Please ask for: Simon Algar  
Tel No: 01795 417375  
Our Ref: 18-506440-PAMEET  
Your Ref: -  
Date: 5<sup>th</sup> February 2019

**18/506440/PAMEET - Request for Pre-application planning advice - Derbies Barn, Stalisfield Road, Stalisfield - Proposed amendments to approved applications: Ref SW/01/0383 and SW/01/0384.**

Drawing Name
Proposed Ground & first floor Layout plans & Elevations

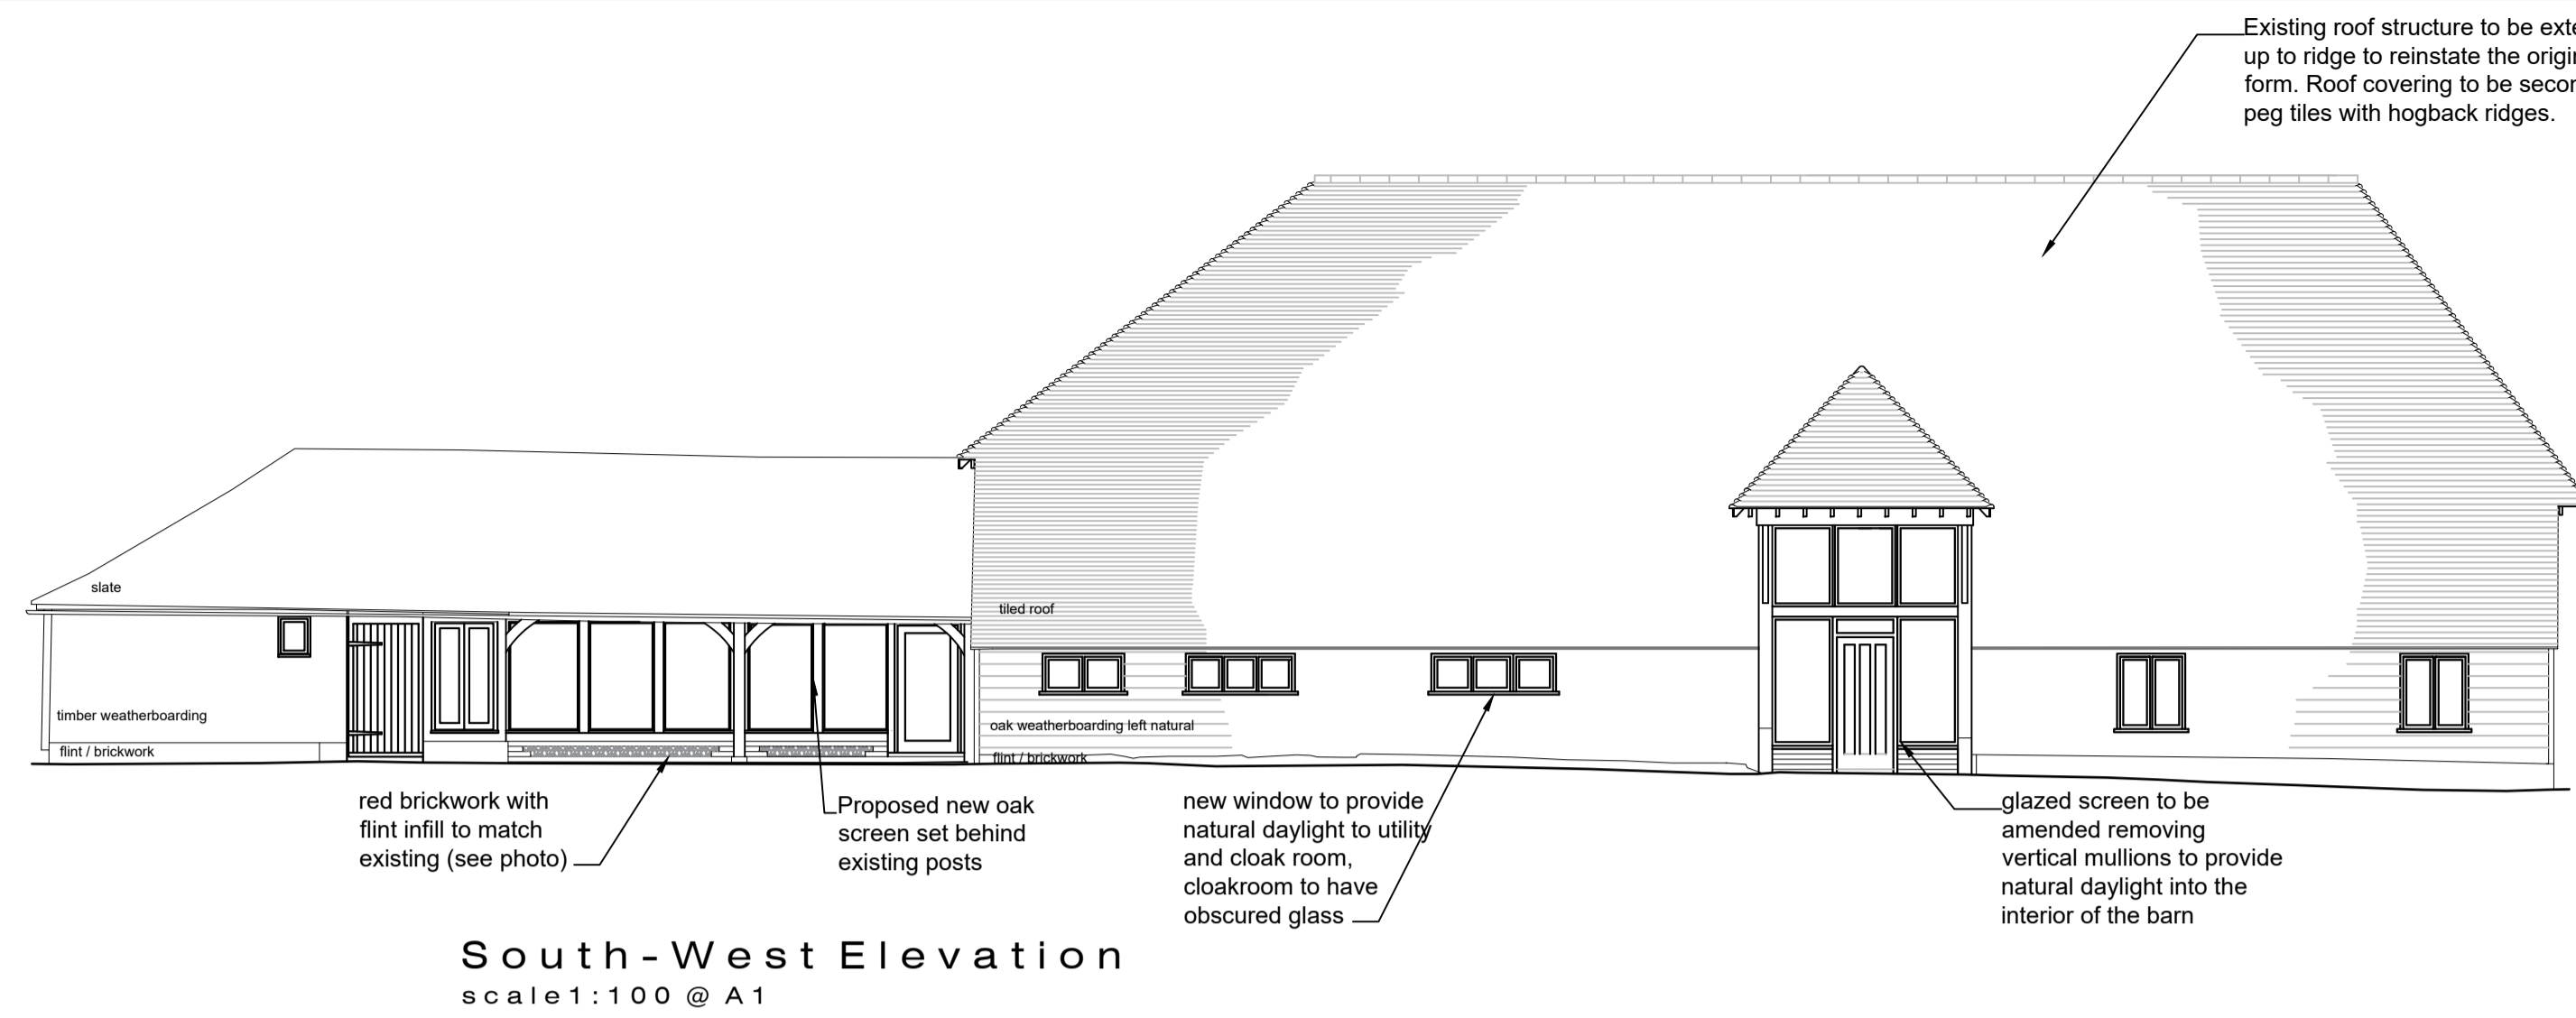
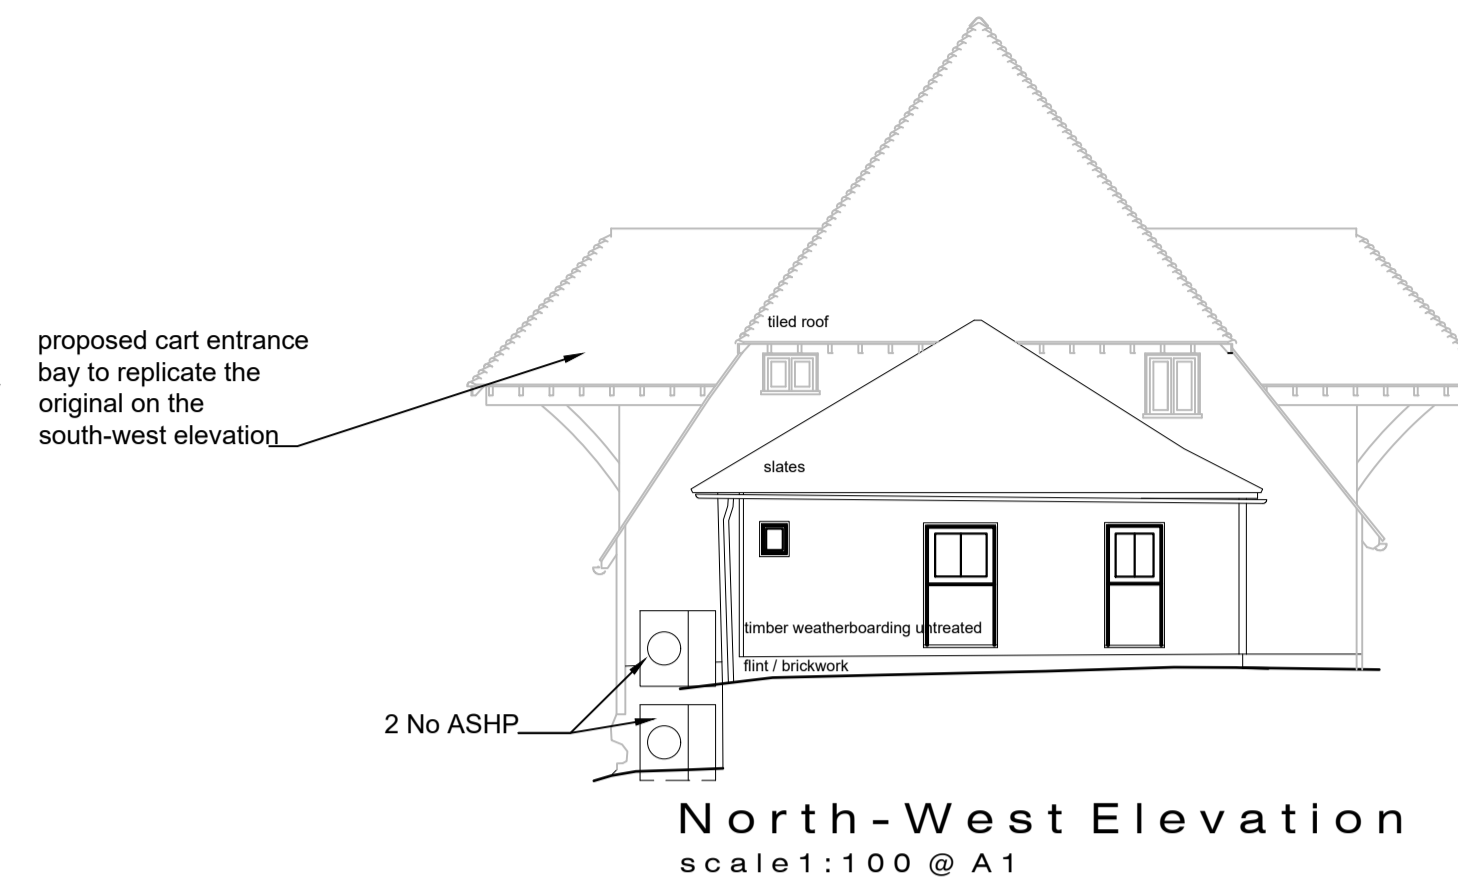
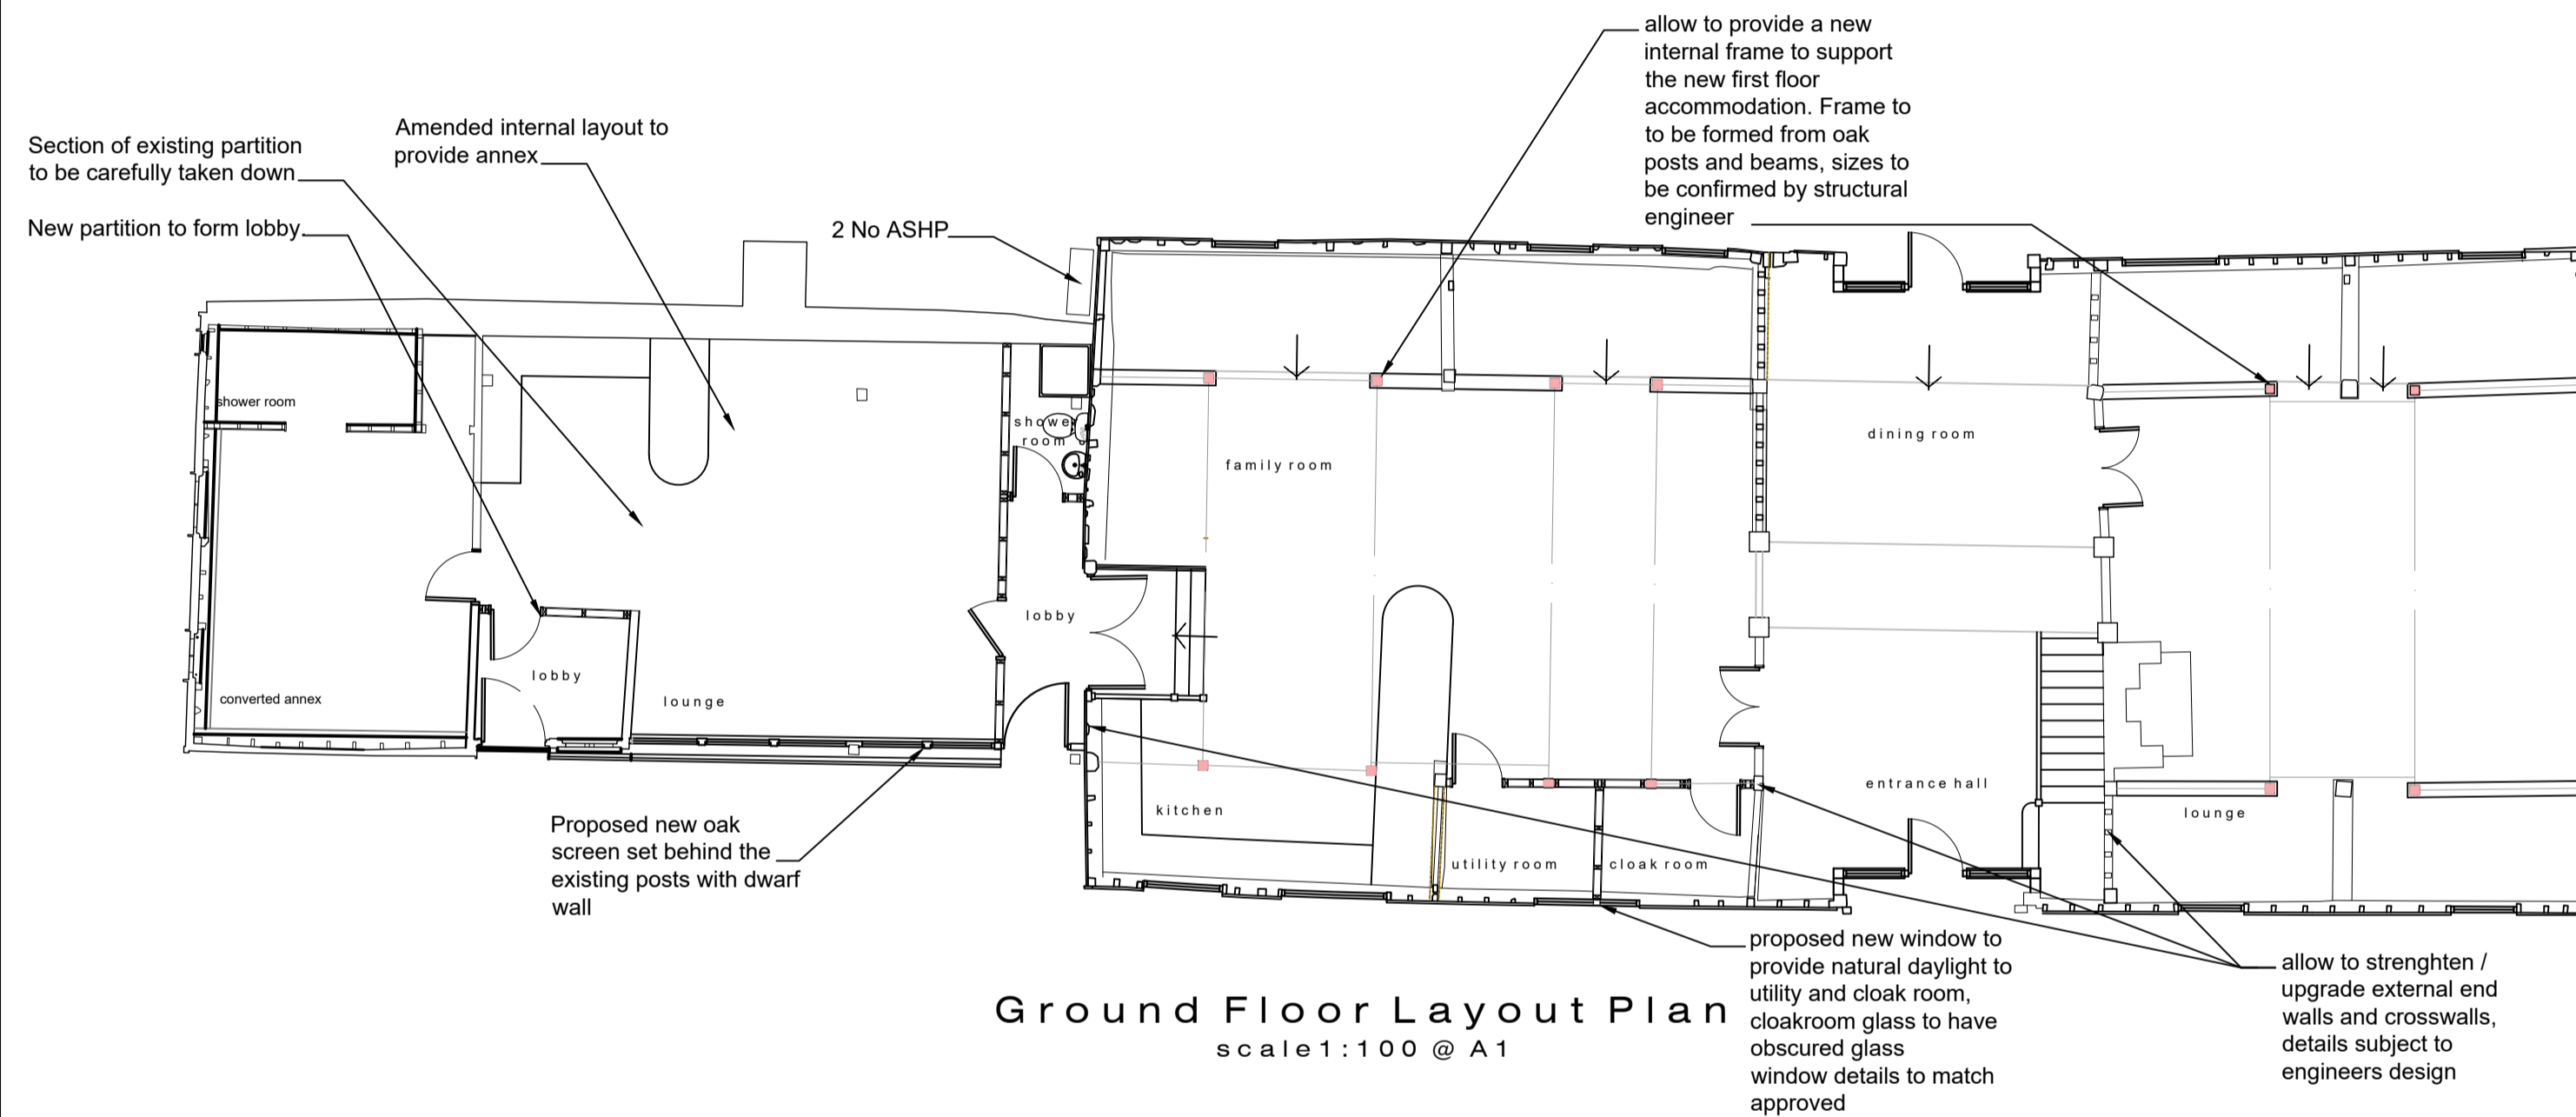
For the avoidance of doubt, I would confirm that the roof (as with the previous approved scheme) would need to be altered above the level of the purlins and tie beams to rise to a ridge, as would originally have been the case, prior to the truncated form we see today. Details of how this would be effected must be shown clearly on drawings for any revised scheme.

We touched on the issue of the roofing material for the adjacent outbuilding and I can confirm that if the main barn is to be re-roofed in Kent Peg tiles, then this smaller outbuilding should also be re-roofed in the same manner. Please note for your information (in case you weren't already aware) that this little building is listed in its own right (see list entry number 1069203 on the National Heritage List for England) and was originally constructed as a granary, hence its raised ground floor level on the staddle stones.

forward in the form of timber studs set back behind the line of the existing corner and central support posts and their associated brackets. Double glazed panels could be inserted between the studs, and these and the associated glazing would need to sit on a shallow red brick and flint work plinth to match that in use at the far north western end of this single storey addition to the main barn. You would also need to demonstrate in the planning application that there is sufficient car parking and turning space for at least 2 cars.

As discussed, the existing design in this respect was carefully considered at the time and represents a design approach broadly in keeping with the Borough Council's adopted supplementary planning guidance on the Conservation of Traditional Farm Buildings (see: <https://www.swale.gov.uk/assets/Planning-Forms-and-Leaflets/ConservationOfTraditionalFarmBuildings-feb-2011.pdf>). Your suggestion to alter this by effectively placing sheets/panels of glass of varying sizes in front of the studs is unlikely to be acceptable as a wholesale replacement design approach, but if you remain wedded to this idea, favourable consideration could possibly be given to the use of this approach as a feature wall in the relatively discrete location of the northernmost bay of the barn on the rear, NE facing elevation. This would be in lieu of some of the existing weatherboarding to this wall plane, and I would suggest that the panel of glass would need to be fixed to an external dark stained timber frame butted up against a section of weatherboarding at either end and fixed to the sole plate and wall plate using colour-matched wedges, if necessary to ensure that a true vertical plane could be achieved. I would suggest that non-reflective glass should be used for this proposed feature, and should you wish to pursue this idea further, it would need to be presented as part of a revised set of application proposals (along with the aforementioned proposed changes), and supported appropriately by a large scale part elevation and sectional drawing prepared by a conservation architect.

As discussed, it is not clear why the ground levels are raised as they are towards the door opening on the elevation in question but it may well serve a structural purpose rather than, or possibly in addition to, a practical purpose providing a base on which to step down from the barn onto, and vice versa. My recommendation is that the mounding is not removed but improved to provide a safer and more level access platform without making it look like a heavily engineered structure. Should you wish to remove the mounding and replace it with a simple, dark-stained set of wooden steps and landing platform with associated posts and handrails, then I would advise this would need to be shown in drawings as part of any revised scheme, and supported by a conservation accredited structural engineer's report advising on the potential structural implications for the building arising from this proposed change. The report would need to be informed by some limited test pits dug carefully at the junction between the wall plane and the earth mounding.
